From: Matthew Pickup [REDACTED]
Sent: 11 October 2013 09:22
To: Janice Chapman
Cc: Bryan Fry
Subject: RE: BR/212/13 - Changes to window details on the front east elevation, Flint House/The Old Bakery, Bakery Lane, Bognor Regis

From: Janice Chapman [REDACTED]
Sent: 10 October 2013 14:17
To: matt@ptplan.co.uk
Subject: BR/212/13 - Changes to window details on the front east elevation, Flint House/The Old Bakery, Bakery Lane, Bognor Regis

Drawing Number 4834/10.

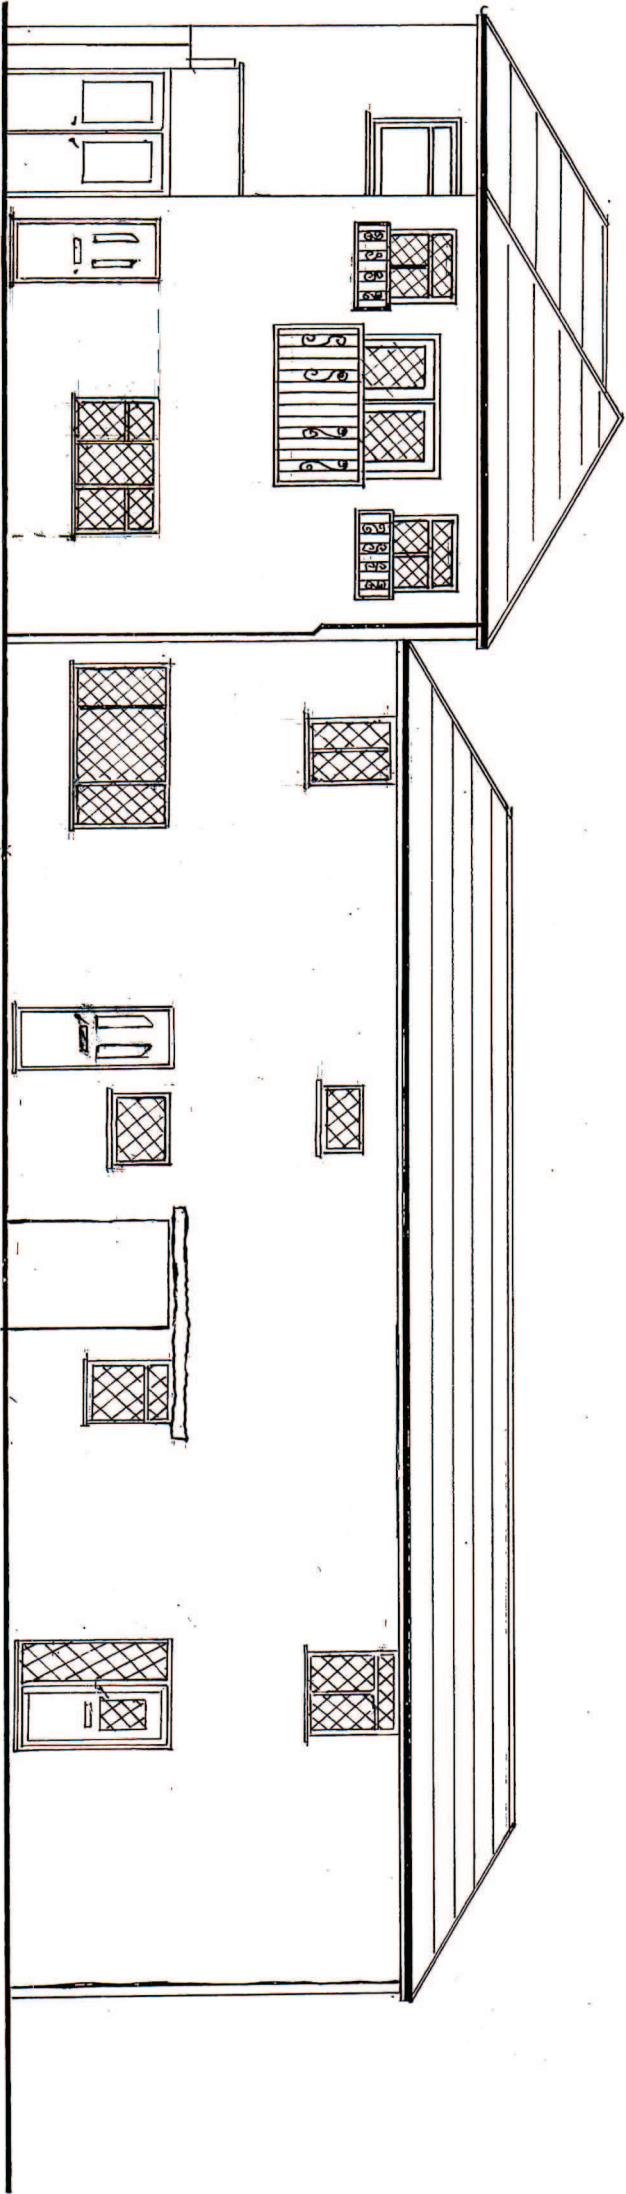
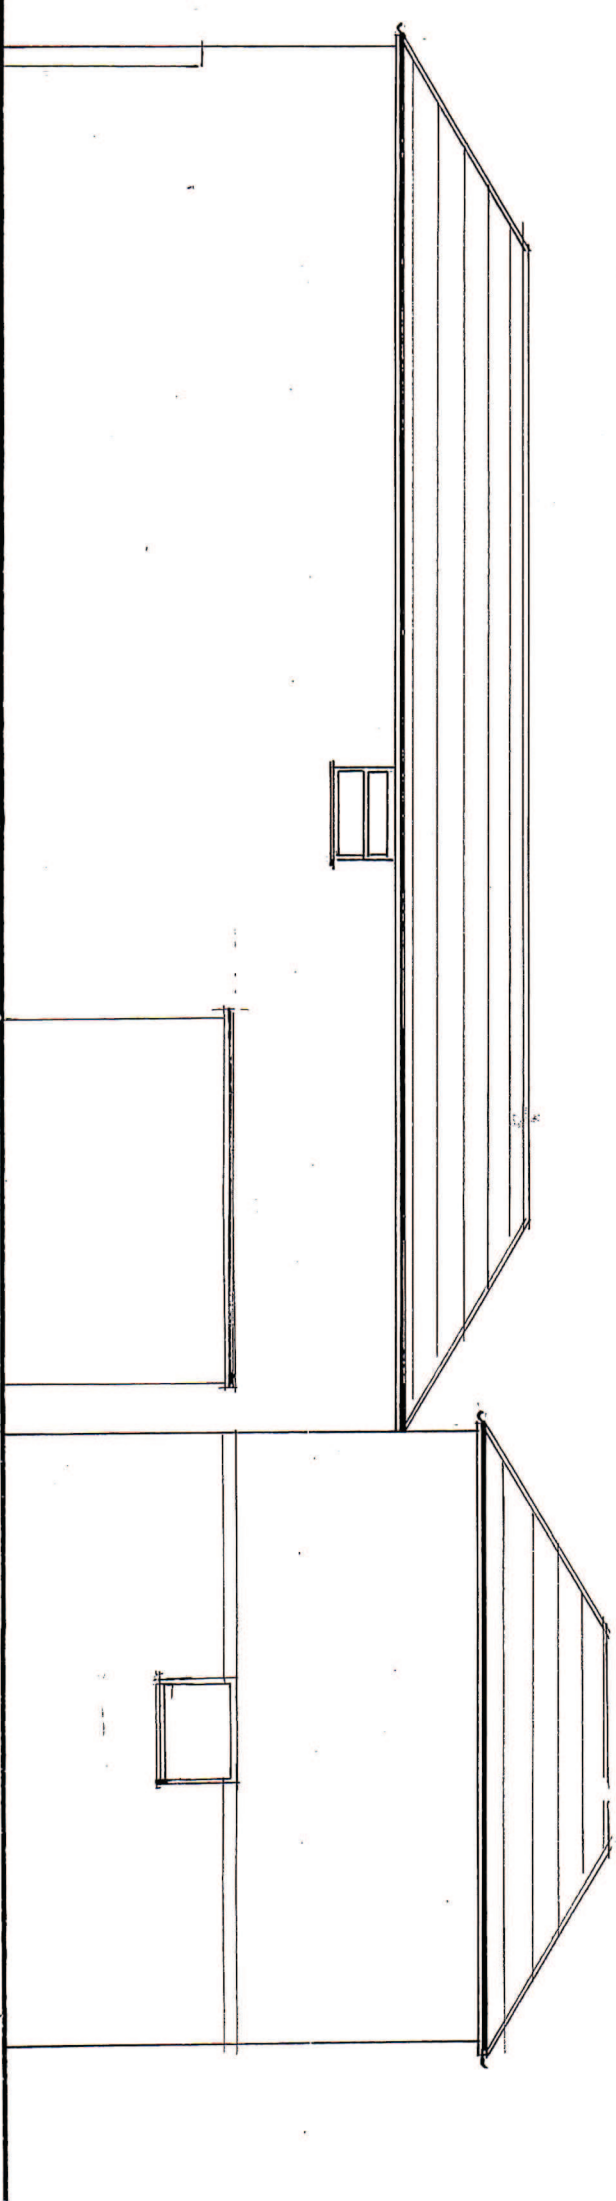
From a site inspection the existing windows on the front elevation are a mixture of white and brown PVCu. The application states that the windows are to be white PVCu with leaded lights. I am of the opinion that brown windows would be more appropriate on this elevation as they would be more in keeping with the brickwork/flintwork.

Would you be happy to amend the application.

My client has now confirmed that he is happy to change the colour of the window frames from white to brown as per your email.
